City of Albuquerque

November 29, 1995

RE: DRAINAGE PLAN FOR DATACO @ 2408 ALAMO SE (M16-D11C)
ENGINEER'S STAMP DATED 11/1/95.

**GRADING AND DRAINAGE PLAN**

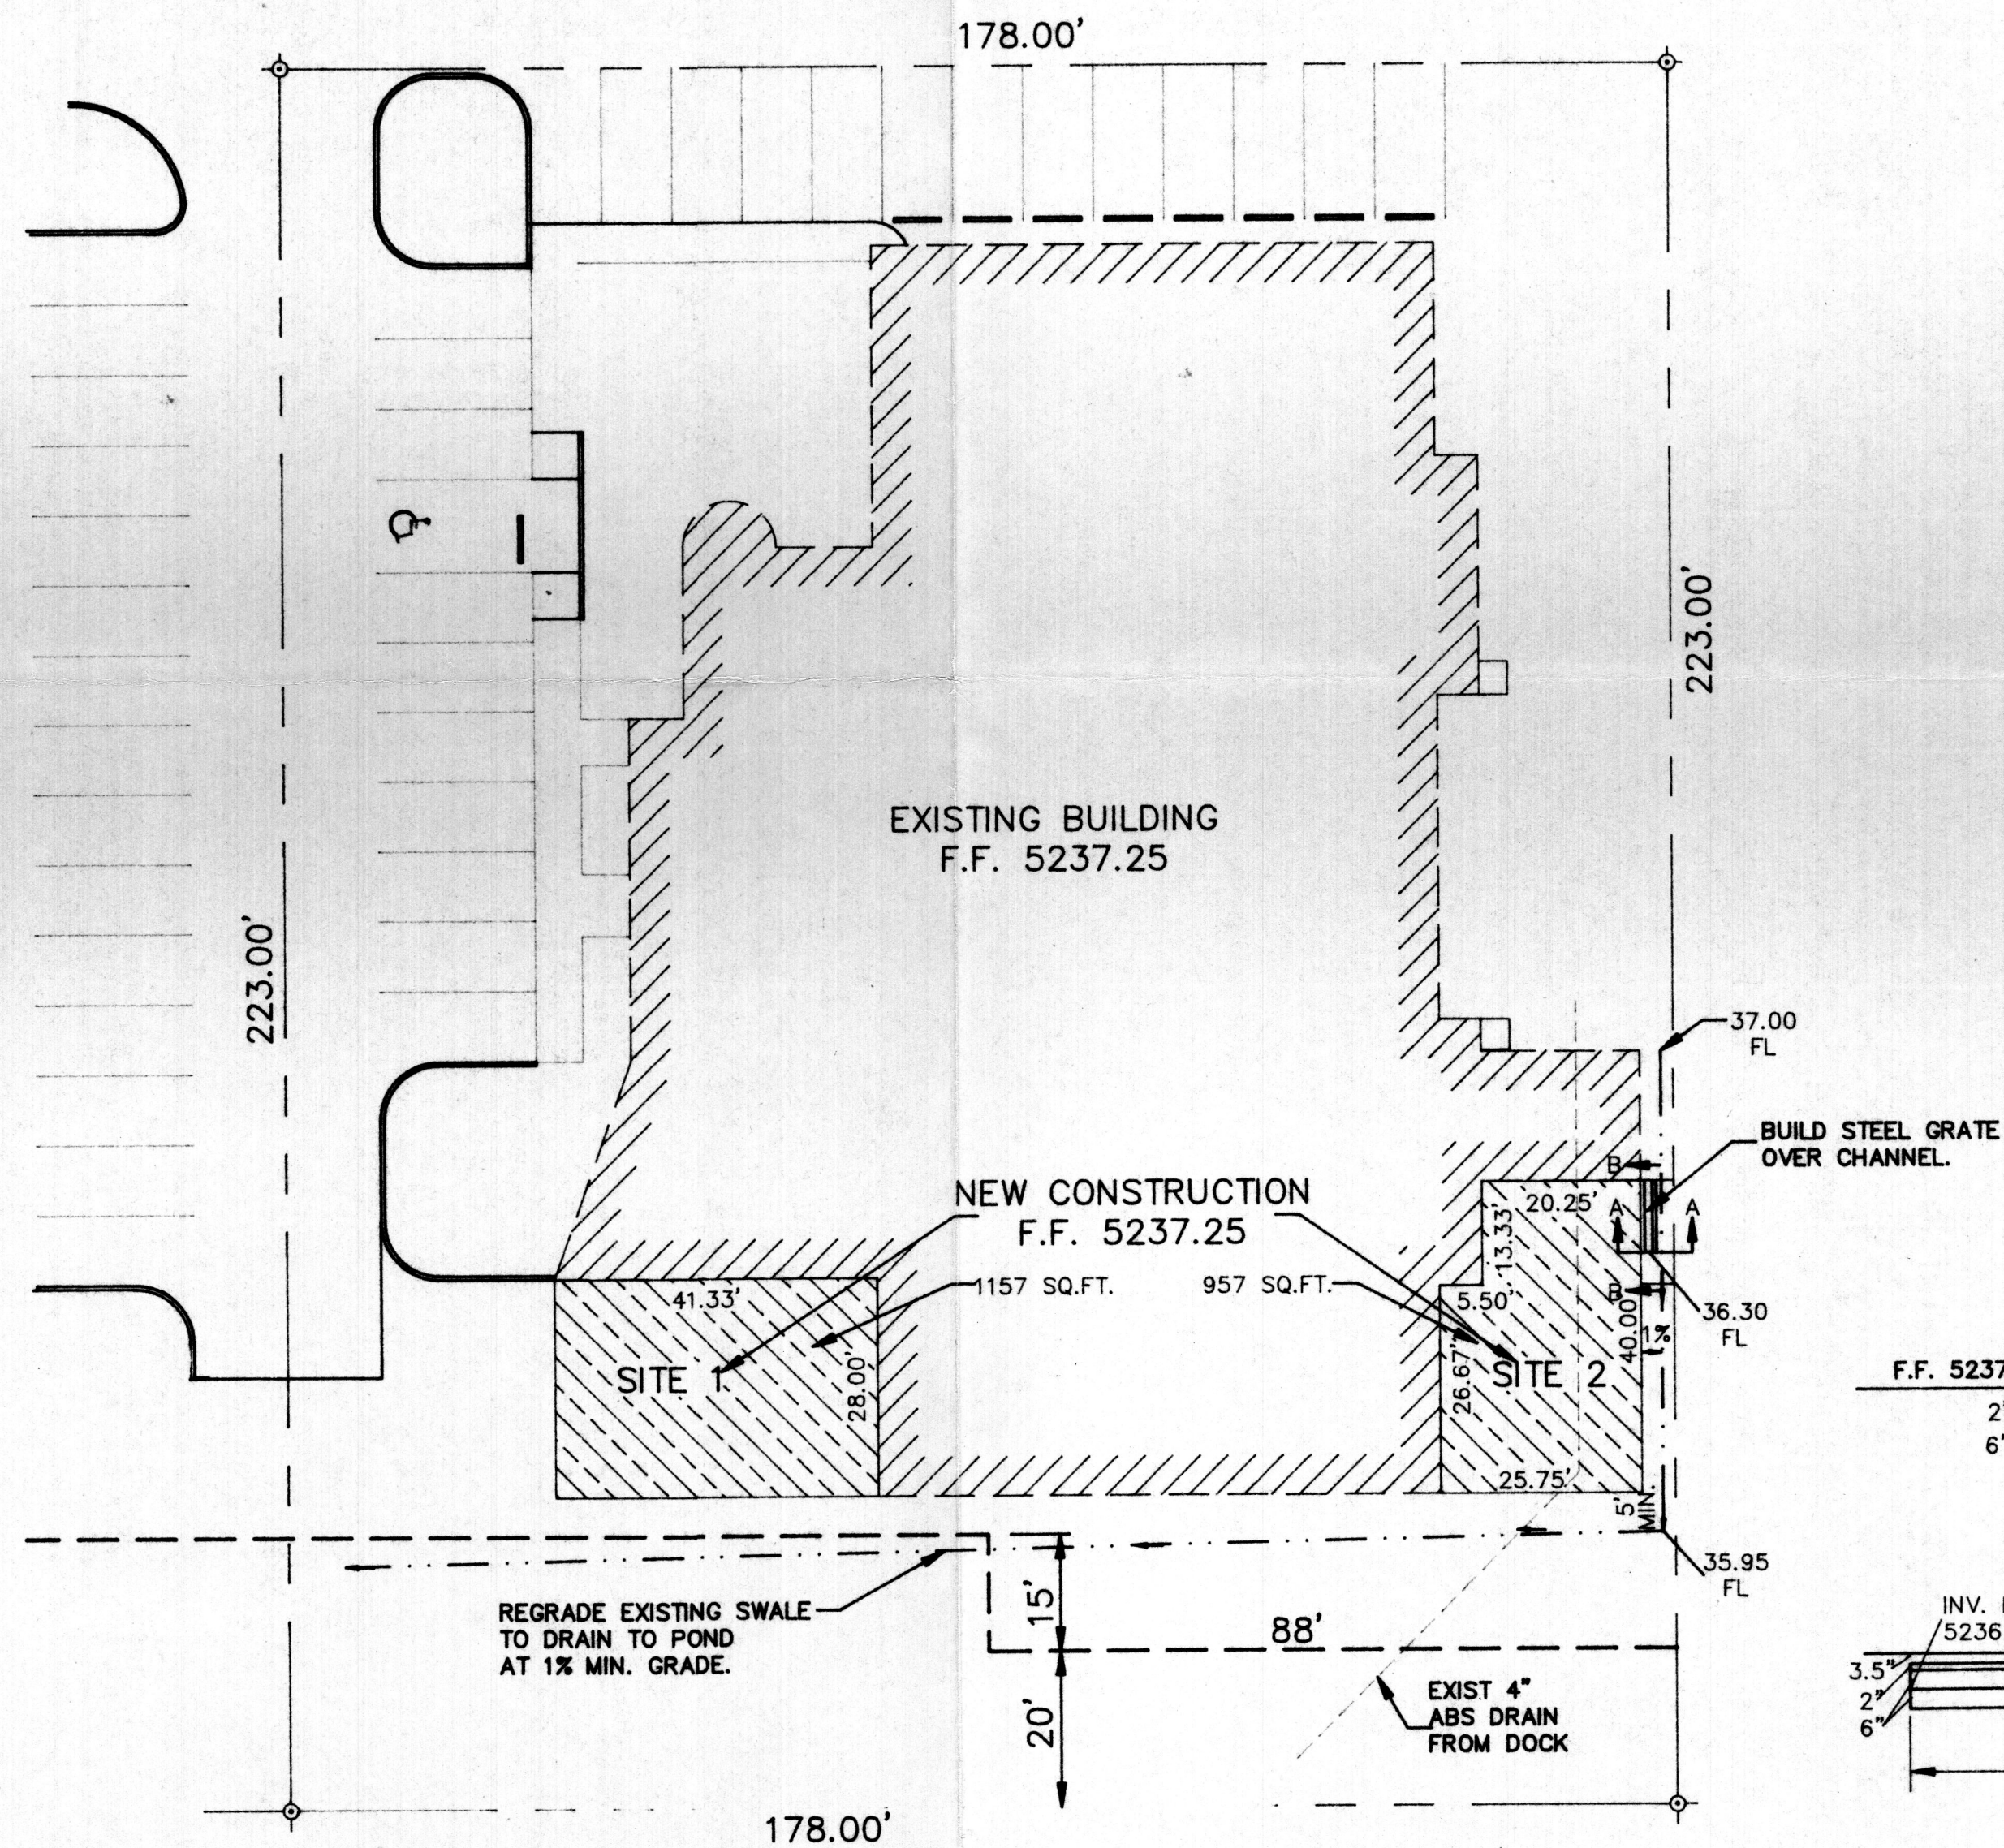
All developed run-off must be routed towards the existing ponding area.
